Our Ref: EP/3/20/PL

**Town & Country Planning Act 1990 (as amended)
Town and Country Planning (Development Management Procedure) (England) Order 2015
Application for Planning Permission**

Development Erect a cast iron column/post to match the existing lamp posts to attach CCTV
Location Village Green Sea Road East Preston

4m, Base Hinged Gainsborough  
Column c/w Size 2 Victoria Lantern

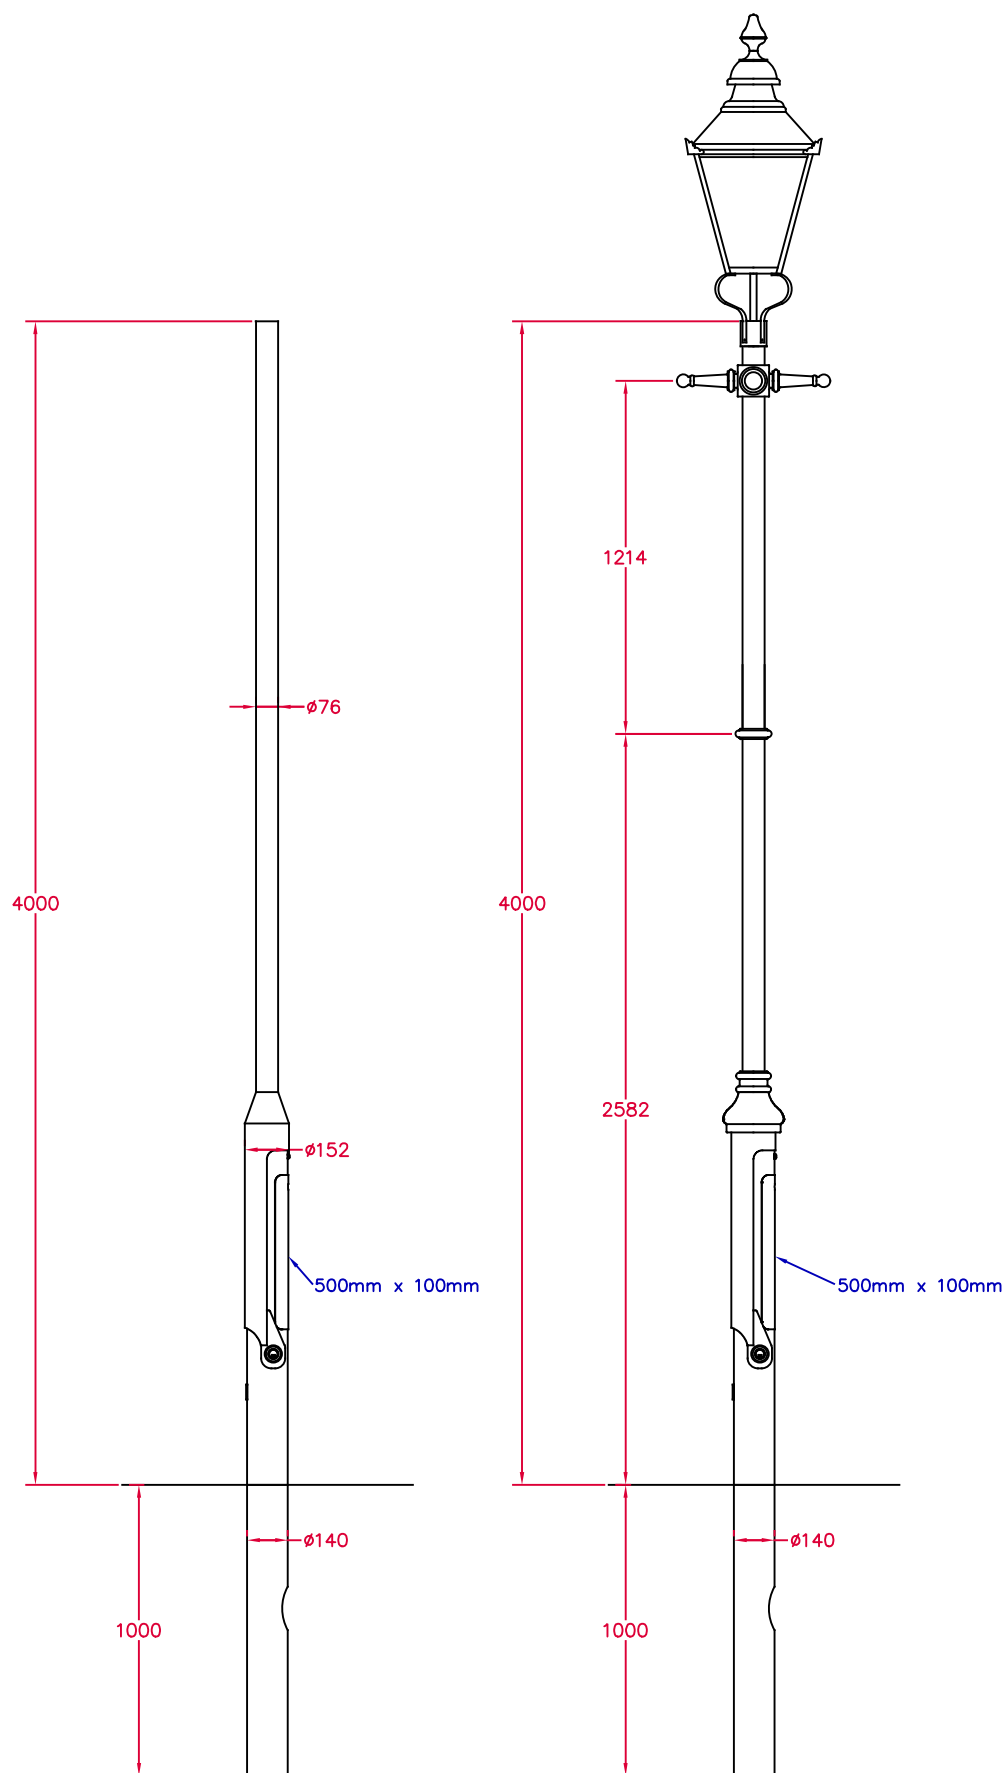
Please provide amended drawing/photos (to scale or with clear metric measurements) of the proposed post along with details of the CCTV.
